Ref: 204327A/Do2

Oakdale South Estate – Review of the SLR September 2015 Noise Impact Assessment

- *DA Noise Impact Assessment, Oakdale South Estate, Milner Avenue, Eastern Creek, Report Number 630.11166, Revision 2, 8 September 2015*

Figure 1 SLR noise logging locations (extract from SLR Report)

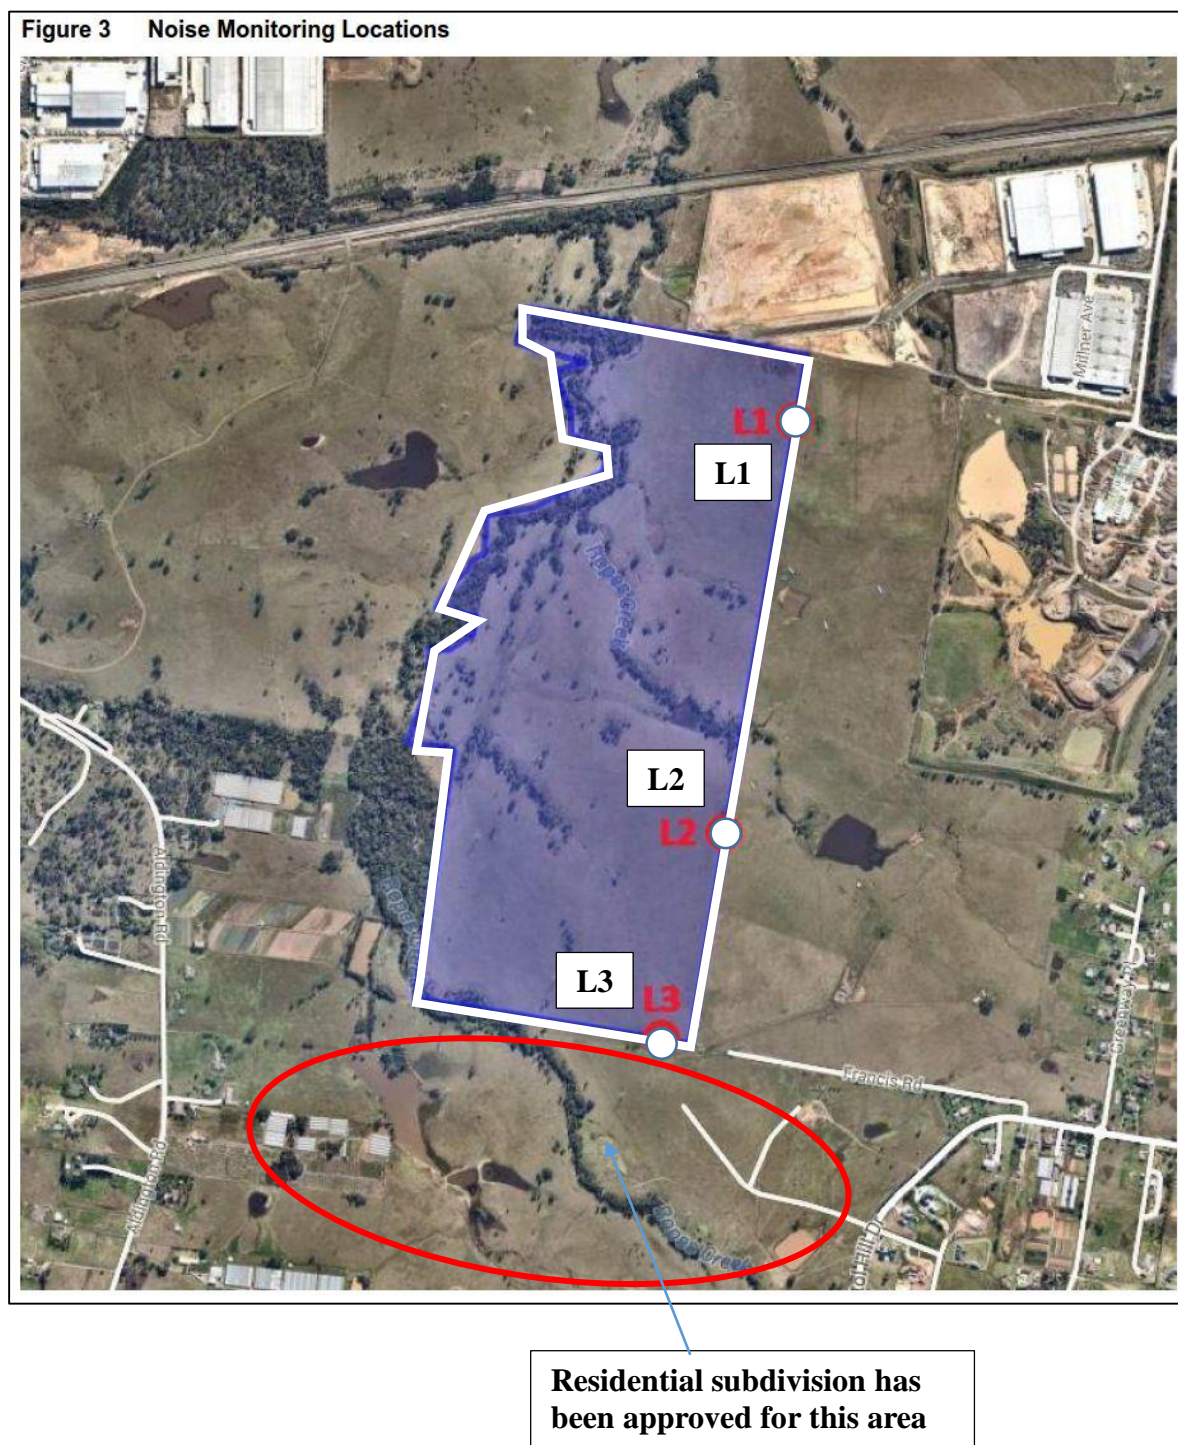
At the very least, the noise loggers used for the SLR assessment should have had filters to exclude insect noise. In addition, night-time sound level measurements should have been carried out once it was clear that the background sound levels were anomalous.

Figure 1 and Figure 2 show the two relevant sites for the two impact noise assessments and the noise logging locations used by SLR and WMPL, respectively.

The WMPL Report labelled this area as “Future Residential” but Residential subdivision has been approved for this area

Further, the planning authorities have not considered the cumulative noise impacts of both of the proposed industrial sub-divisions shown in Figure 1 and Figure 2. This is a gross oversight since it is known and understood that the whole area north and north-west of Francis Road will be developed for industrial use. To consider each development individually is simply to understate the cumulative noise impacts.
